TO: Building Inspection Dept., City of Portland
FROM: James A. Moran III, PE
DATE: 11-12-2013
RE: 46 Avon Street, Portland
FILE: 13368

At the request of Owner Tim Follo we reviewed the new stair construction at the 46 Avon Street address, specifically the connections of the stair stringers to the landings.

Landing Detail

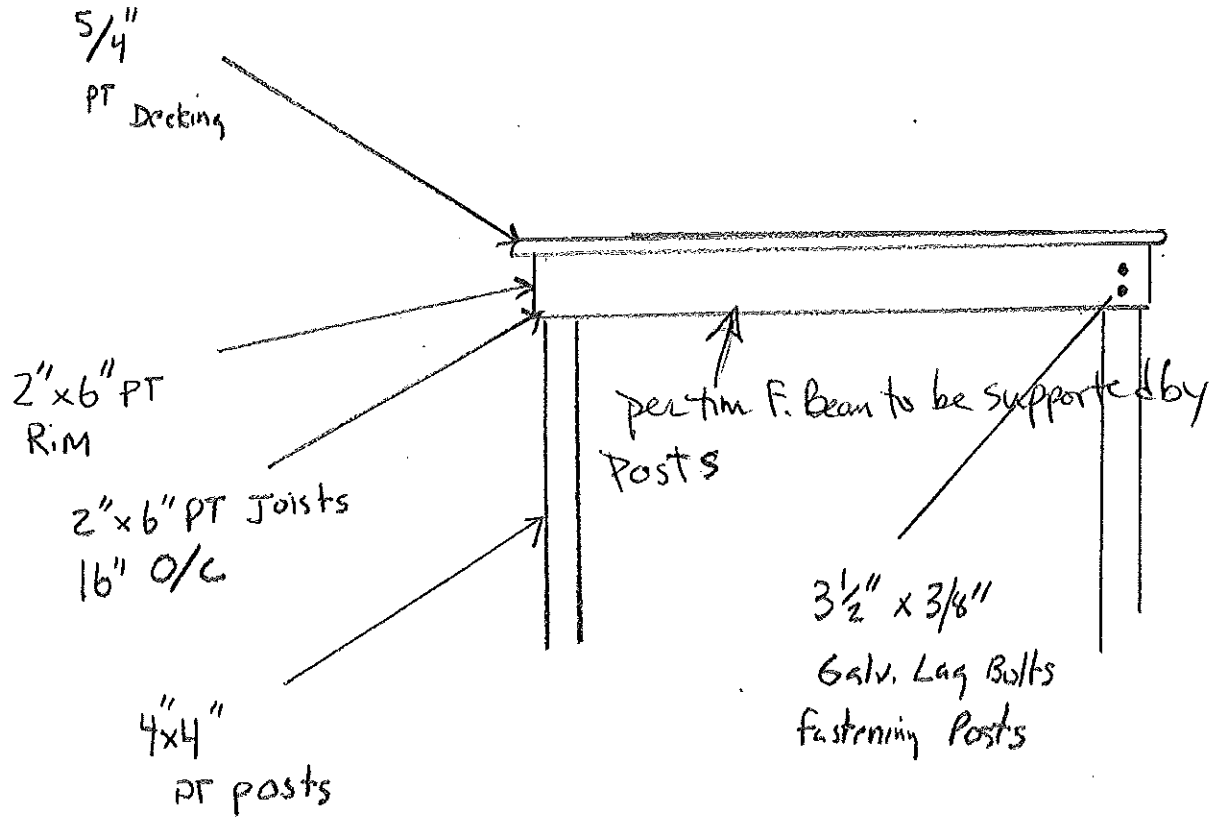
The stair is two flights- one from grade to a mid-landing and one from the mid-landing to the second floor level. The stringers were connected to the landing framing with Simpson flat strap anchors acting as a hanger-type connection.

We performed some calculations and designed a different connection detail. It uses a header installed flush with the stair stringers and the stair stringers are connected to the header with either Simpson stair stringer hangers or Simpson framing angles (where the hangers will not fit).

A sketch showing the connections was provided to Mr. Follo for construction of these modifications.
